**City of Albuquerque Stormwater Construction Site Inspection Report**

ESC File No.	L09E042A	Project Name:	Mercado El Milagro Bldg. D (Federidelfo's)		
NPDES Id. No.	NMR10056E	Location:	10000 Central Ave SW		
8/29/2025	Owner	Contractor			
Operator	PPI II, LLC	Wilger Enterprises			
Contact name & title	Doug Peterson	John Wilger			
e-mail	<a href="mailto:doug@petersonproperties.net">doug@petersonproperties.net</a>	<a href="mailto:jwilger@wilger.com">jwilger@wilger.com</a>			
Contact Phone #	505-884-3578	505-345-2854			
<b>COA Inspector</b>	<b>James Hughes</b>	Start/End Time:	11:30am		
Construction Phase:	Building D complete, needs stabilization				
Type of Inspection:	<input type="checkbox"/> Regular	<input type="checkbox"/> Storm Event	<input type="checkbox"/> Post Storm Event >0.25"	<input type="checkbox"/> 311/Complaint	<input checked="" type="checkbox"/> Follow Up
Weather at time of inspection?	Clear		Temperature: ~	80	
Estimated date of last storm 0.25" or greater	8/27/2025

L1.2

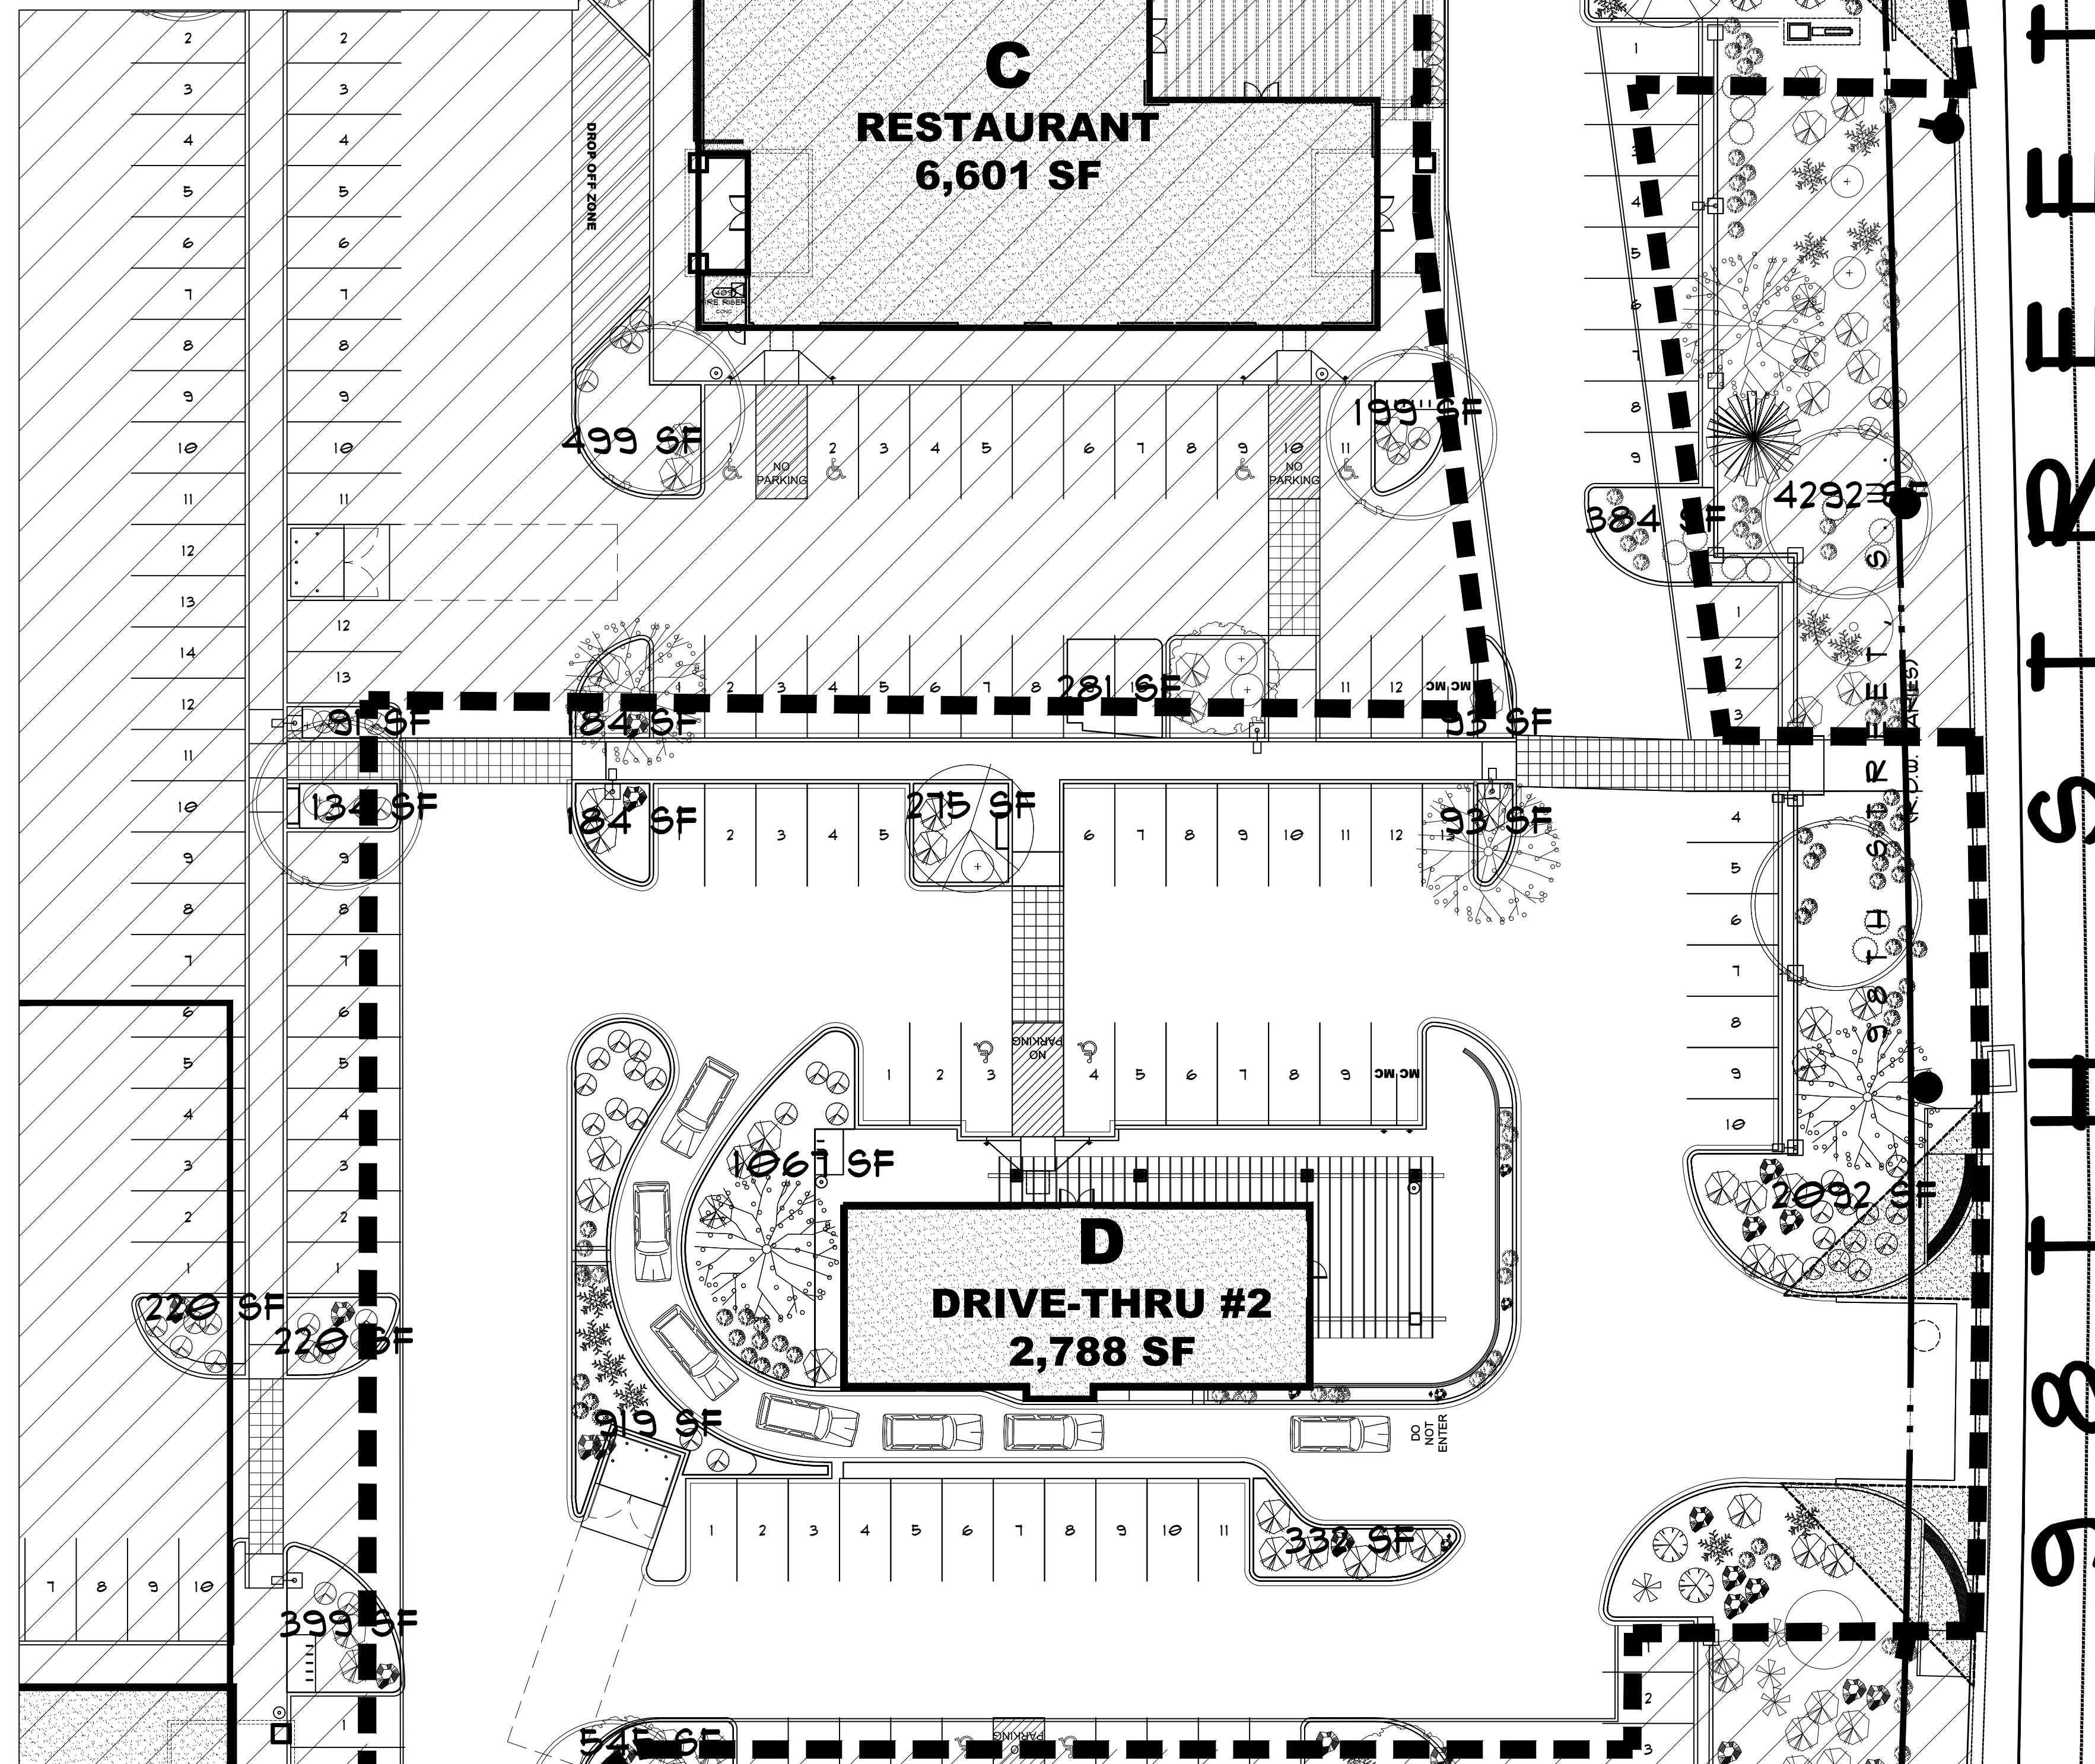
Item Number	Deficiency/ Corrective Action				
1	The SWPPP and posting weren't checked during this inspection. The EPA still shows CGP coverage is "active." Please send copies of the latest inspection report.				
2	The southeast portion of the site has been stabilized with a combination of rock landscape around the streets and seed hydromulch, mitigating previous violations. Two small areas were still dirt, between the sidewalk and curb along Sunset Gardens, and in the parking lot island northeast of the building.				
3	The sediment had been removed from the streets and sidewalks. This is excellent progress since the Notice of Violation was sent on 6/27/25, so extra time will be allowed to complete the stabilization and terminate CGP coverage.
